From: Rosanne Lapan
To: [Lauren Anderson](#)
Cc: [Jim Harnisch](#); [Susan Cook](#); william.ellis2@comcast.net
Subject: Re: Velamoor fence variance petition
Date: Saturday, February 18, 2017 4:02:55 PM

Subject: Velamoor fence variance petition

The Velamoor new house construction is along the northeast border of our driveway which is shared with the Cook family who is our upland neighbor. The Velamoor's have filed a petition with the City for a variance to permit construction of a 6 foot fence along our driveway property line as well as along their border with West Mercer Way. We are concerned that a 6 foot high fence is completely out of character with the neighborhood and would establish an unfortunate precedent for other homes in the area. A feeling of a locked in corridor with diminished open space would be the result. No other homes in our area have resorted to this high fencing along West Mercer. The City's arborist can suggest excellent tall vegetation (such as soldier trees) as an alternative or as a supplement to a lower fence. My point is applicable to both the property line along our driveway as well as that along West Mercer Way.

FENCING PLAN

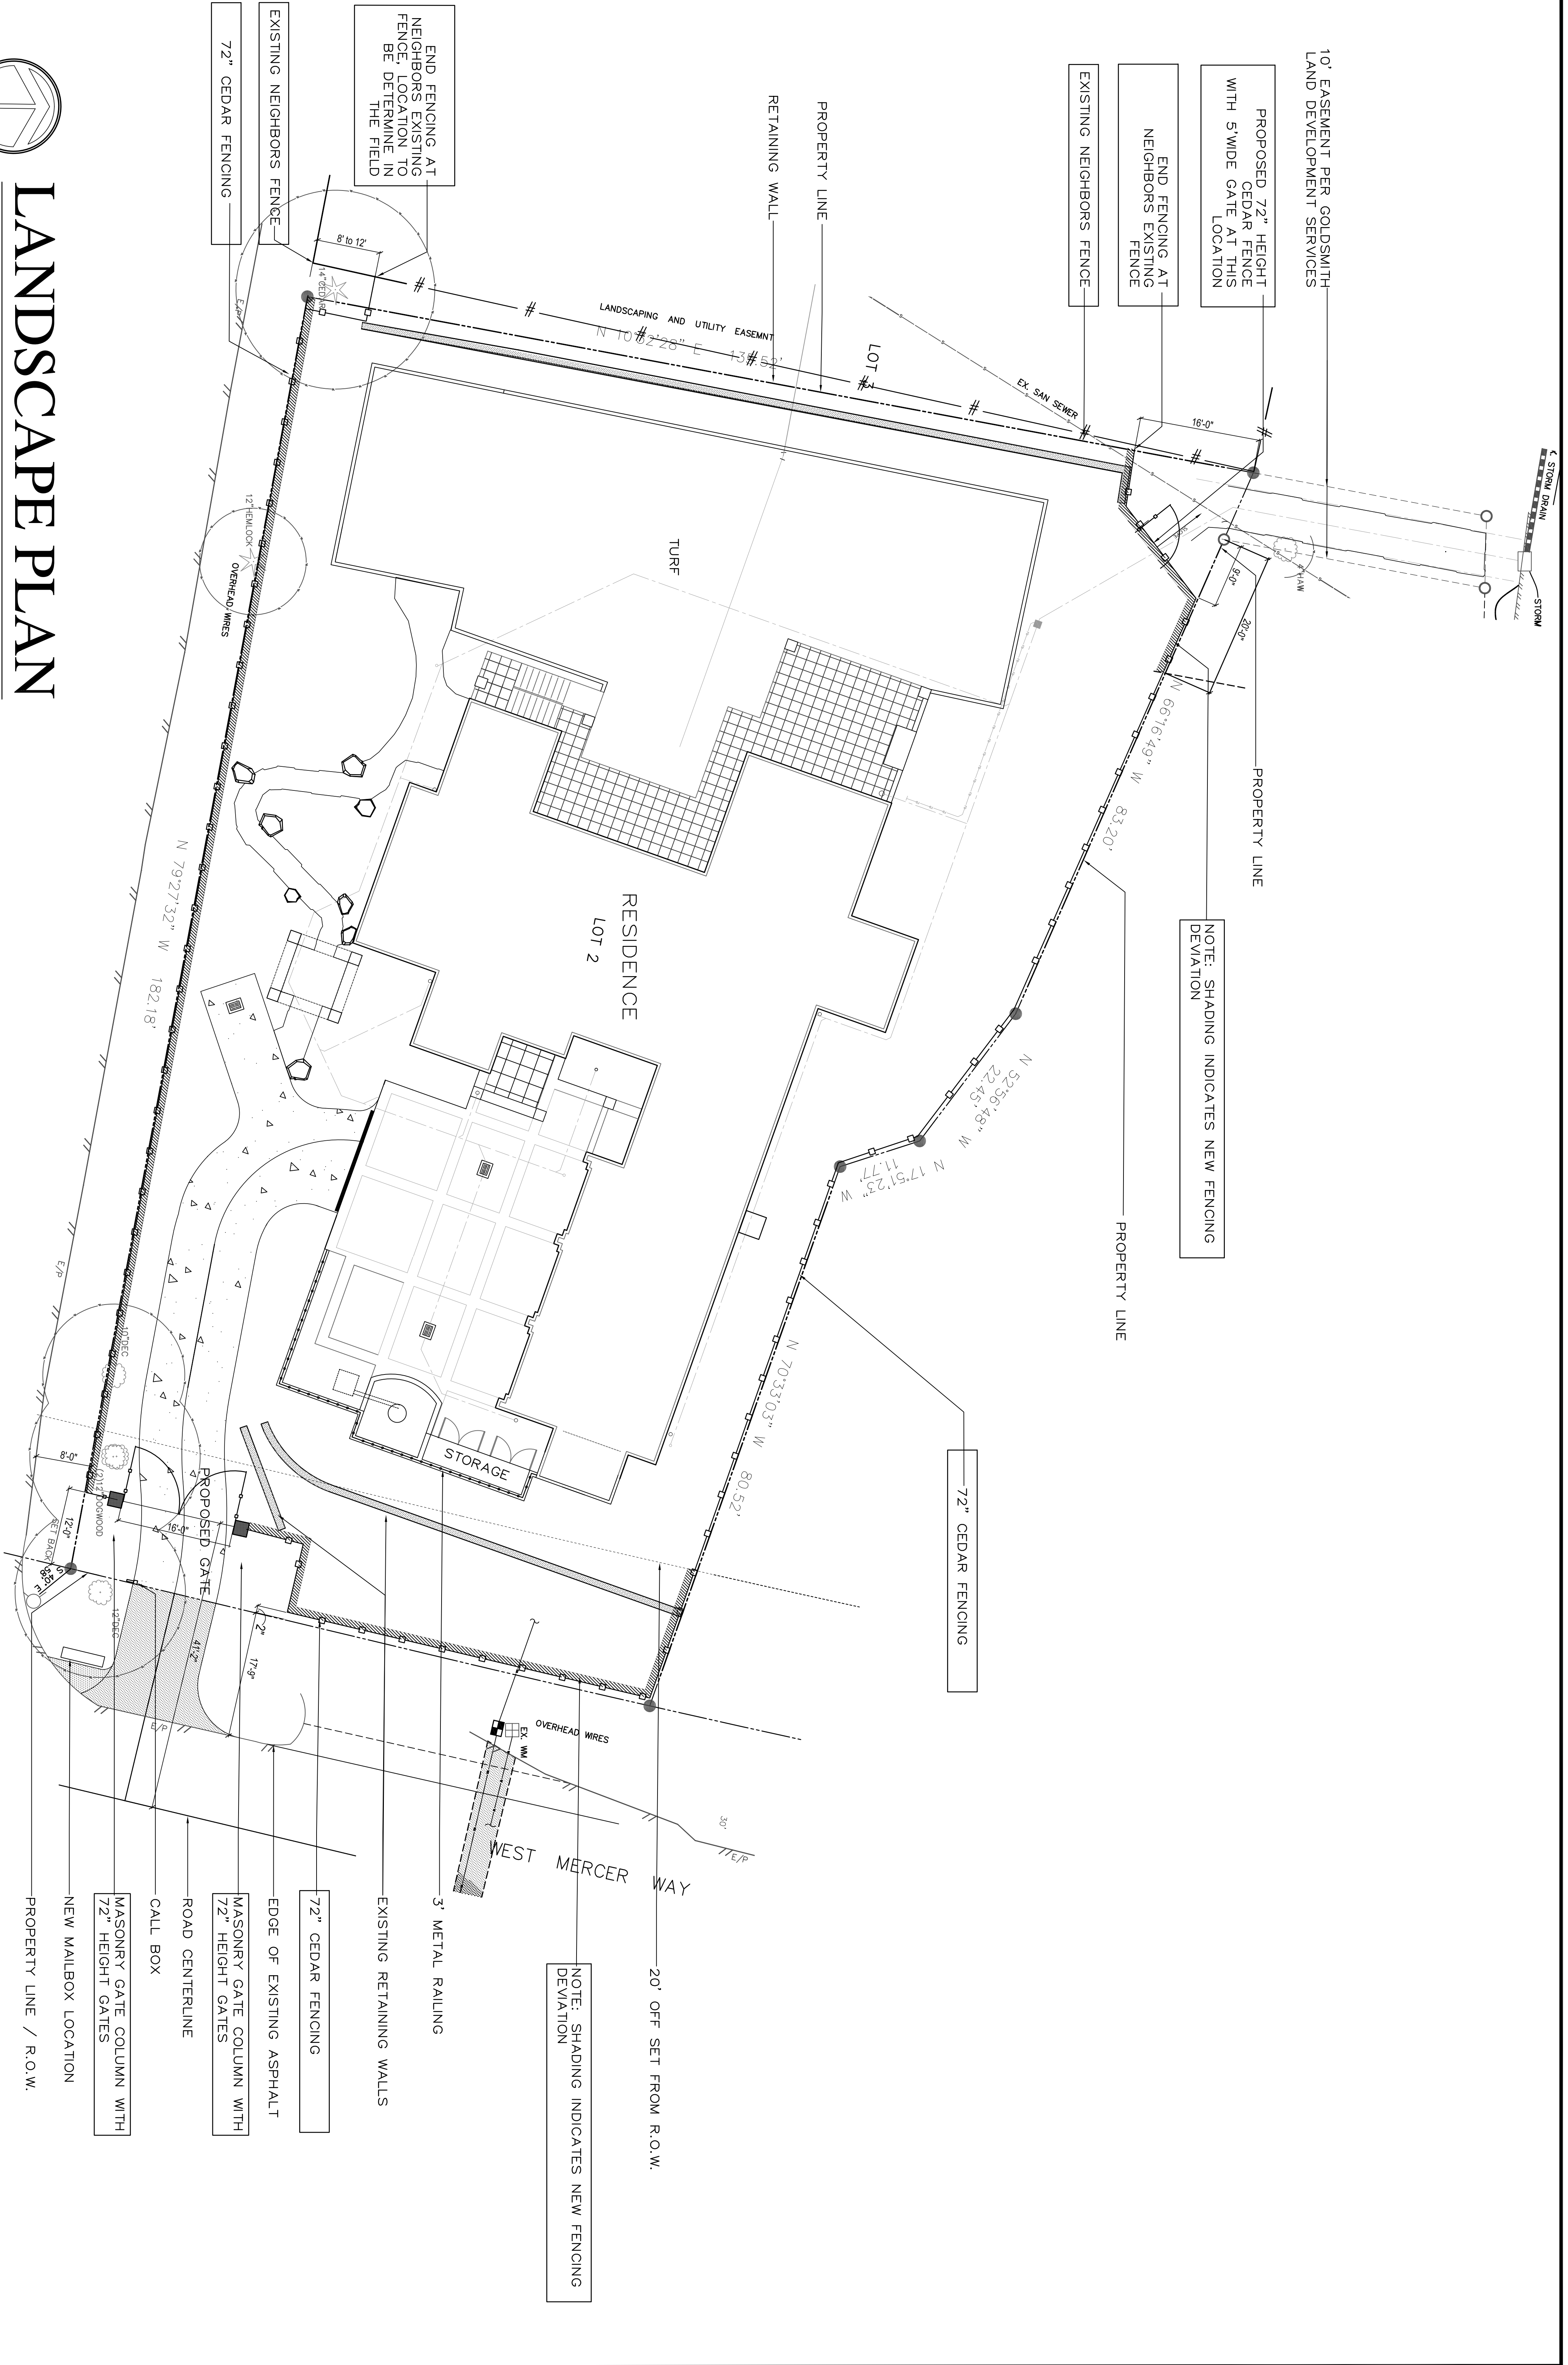
I concur with everything that the Harnish's and Cook's have stated in their objection to this petition. On our Lane, we also have limited visibility as we drive up to West Mercer Way. It is difficult to see approaching cars from either direction, and anything that further affects and reduces visibility will create a more dangerous approach than already exists.

In addition, I strongly agree that a 6' fence surrounding this property is out of character for our neighborhood, and I am concerned that allowing this variance may set a precedent as well.

We also request the City Arborist to provide specific guidance as to the location of fence posts along our mutual property line to avoid root damage to existing trees that already provide excellent shielding.

An added concern is potential reduced visibility looking north when we exit our driveway if a higher fence is constructed. During their 3-4 year construction vehicles have constantly impaired our visibility creating near accidents. Although not the same situation, the higher fence would still reduce visibility. I have reported this safety concern to our Police Department.
